Objection Letter – Change of use of land from agricultural use to residential use, creating 4 No permanent private gypsy plots with associated parking, landscaping and facilities, Land off Church Lane Barnham (BN/97/25/PL)

BN/61/25/PL

Land to the West of Church Lane Barnham

DAY ROOM PLOT 1

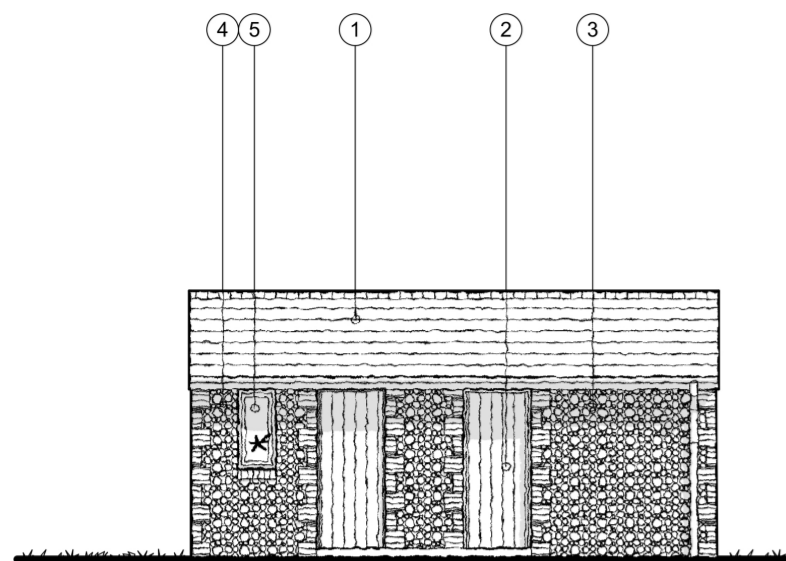
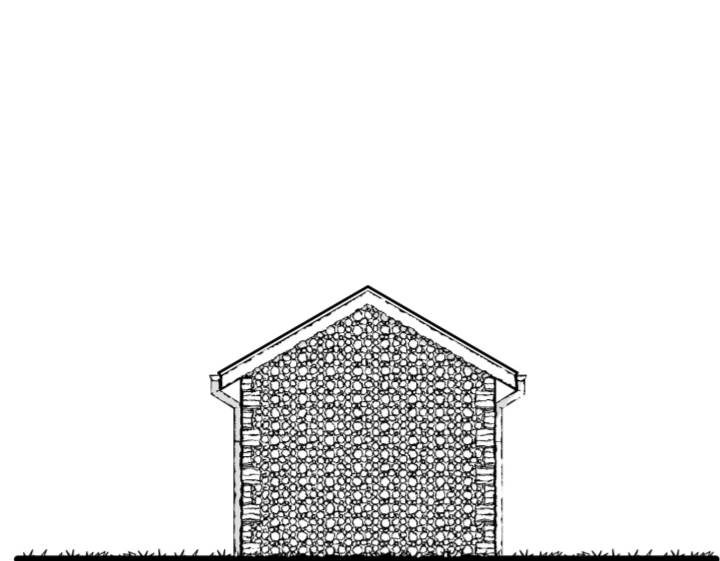
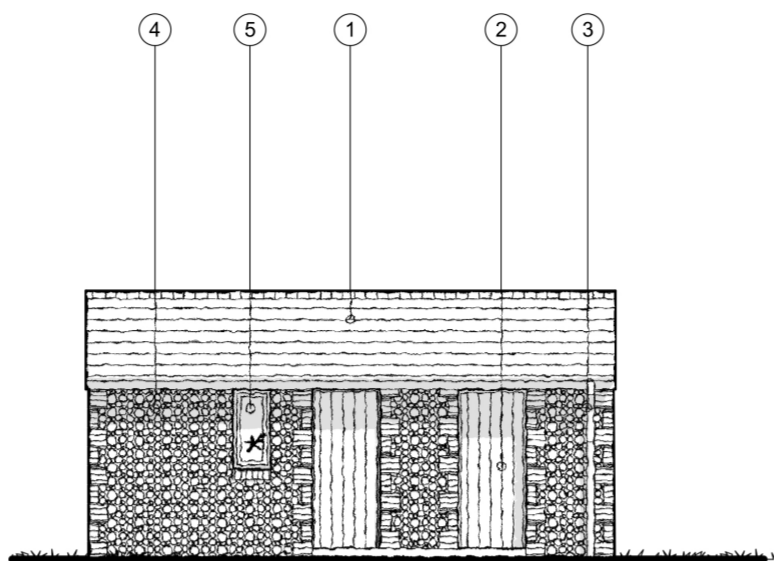
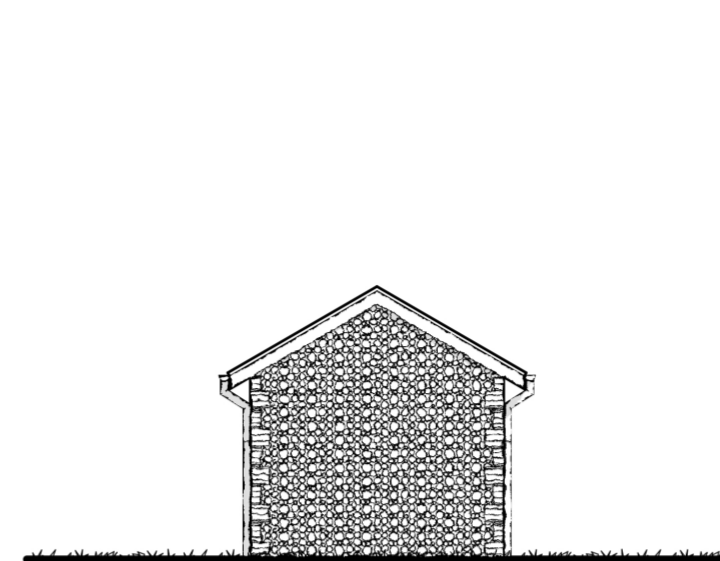
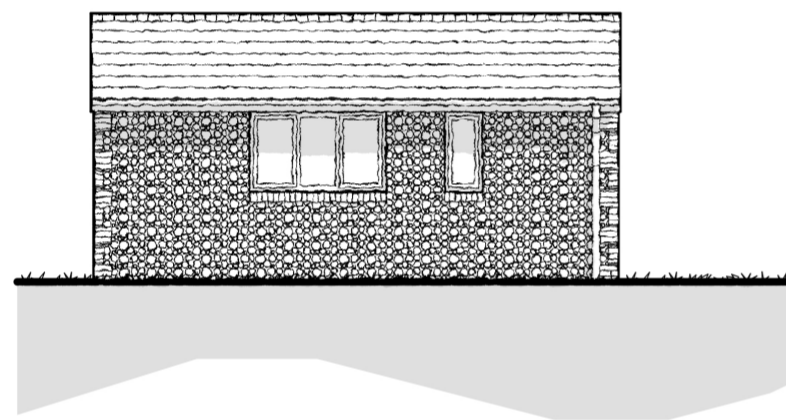
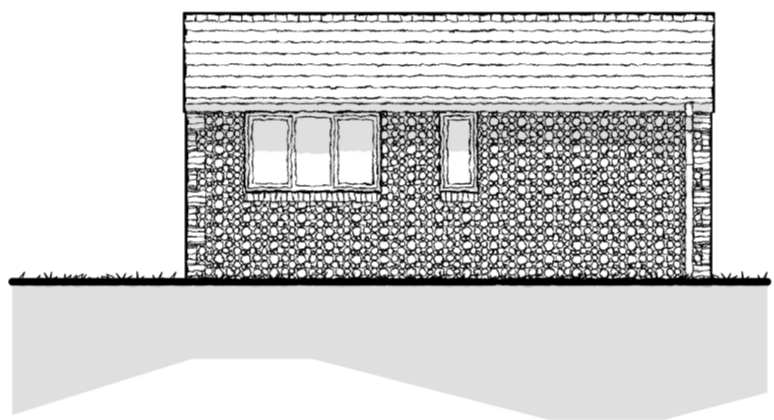
The construction of four plots and additional outbuildings, despite some effort to adopt local style (although slate roofing is not typical for the area), would visually disrupt the traditional setting, introduce incompatible building forms, and undermine the area's protected status. This is in clear conflict with Policies HER DM3 and H SP4 of the Arun Local Plan, which require that any development in conservation areas must preserve or enhance their character and appearance. A similar opinion has also been previously shared by the Conservation Officer under the previously withdrawn application, stating that 'the impact of the proposed development would result in harm to the conservation area, as well as some harm to the setting of the designated other identified heritage assets and therefore harm their significance'.

The proposal incorporates a number of structures into the site. this includes day rooms which will be constructed from what is described as "traditional knapped flint brick with slate tiled roofs to reflect the surrounding architectural styles found locally". Although, it is not clear if this flint work would be hand laid or constructed using flint blocks. I also note that the static mobile homes would have flint elevations in an attempt to reflect the vernacular.

STREET SCENE BB [viewed from Church Lane] [1:200]

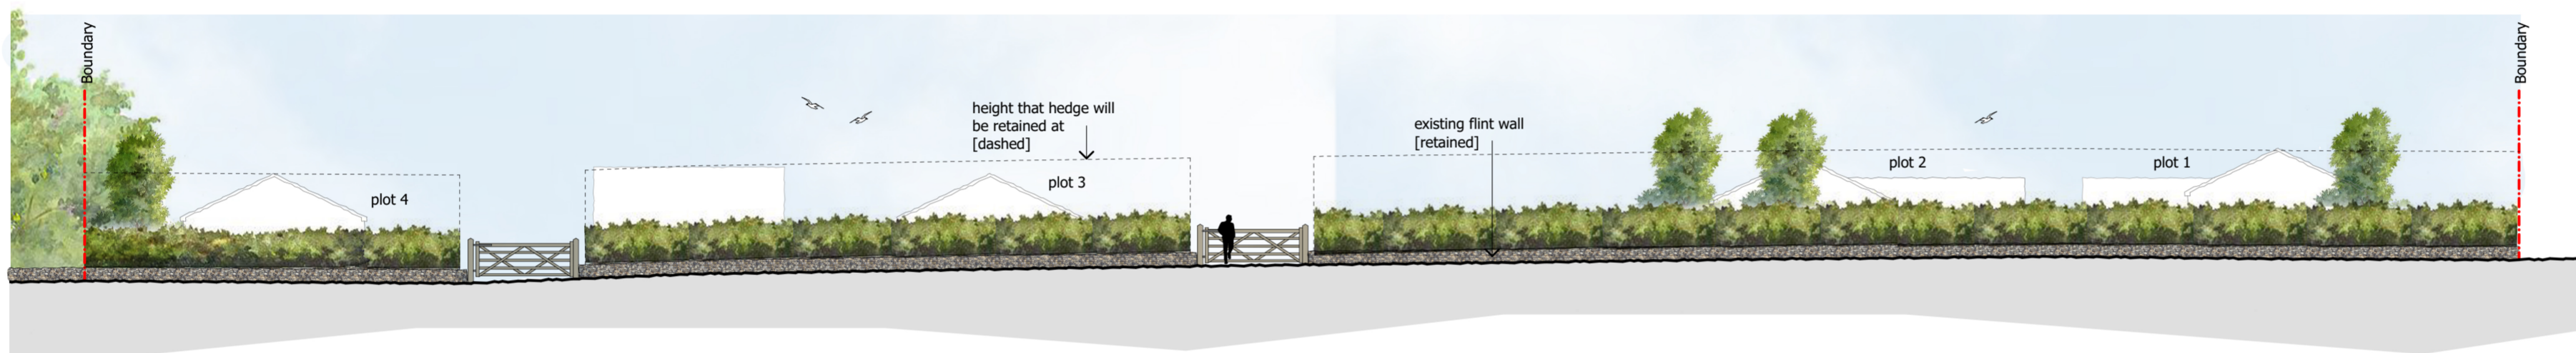
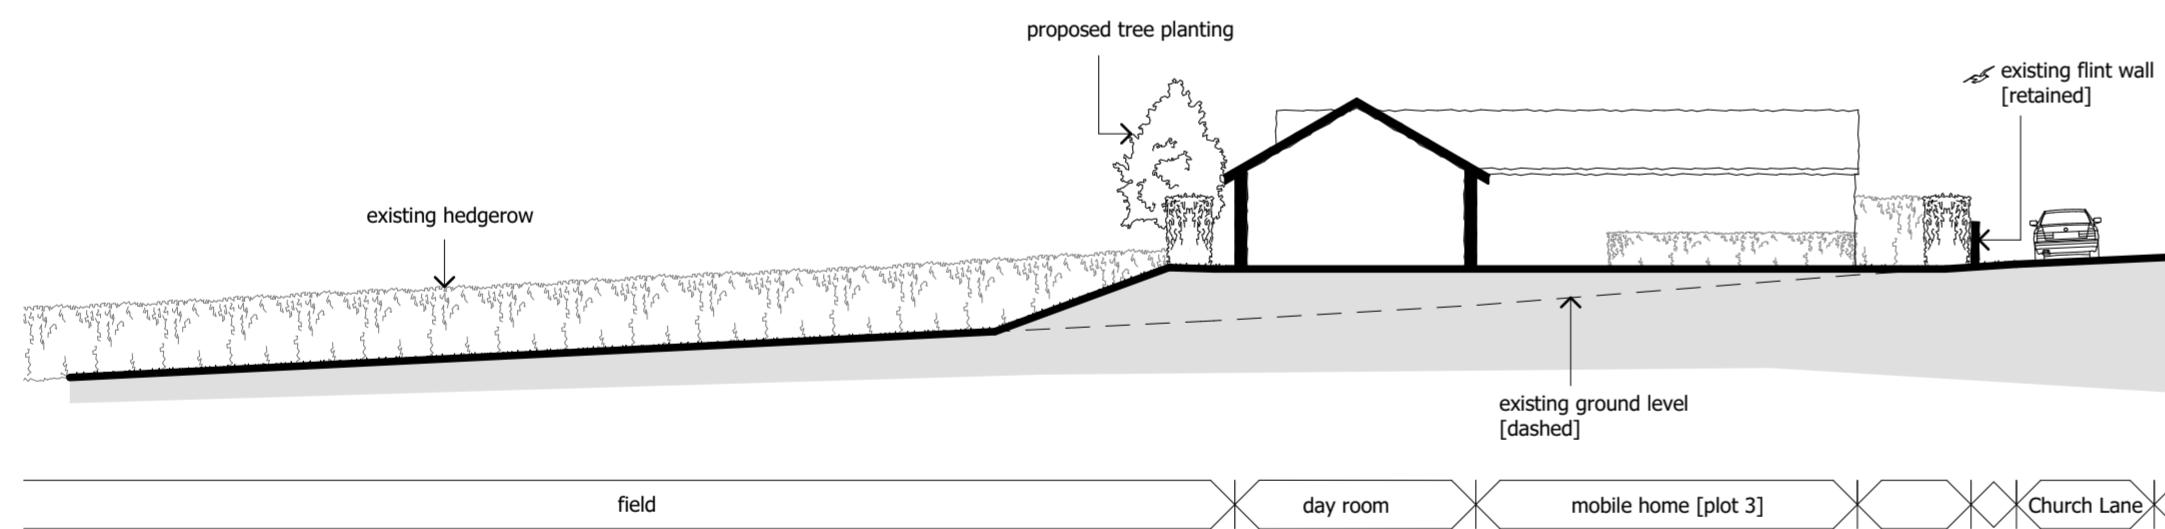
Newly included (and inconsistent) illustrations of the proposed 4m hedging are now included in the application which undeniably demonstrate how the defining rural character of the area will be destroyed from both Church Lane and the now redirected footpath. There is a clear discrepancy between the Street Scene BB projection and those included in the Design & Layout section - the former shows a hedge barely the height of a person whereas the latter shows an excessively tall hedging. Whilst yes there is a dotted line on the Street Scene to show the future hedge retention height, the way it has been communicated does not reflect the long-term character of a mature hedge.

The new application now also includes details of the significant land raising required to avoid flood risk zones, which again would further harm the character of the conservation area. The Conservation Officer has again noted that this 'would further alter the character of the area and increase the ground level of the new development. This would increase the prominence of the development in the surrounding context'. Again, to mention the representation of the Street Scene provided is totally misleading.
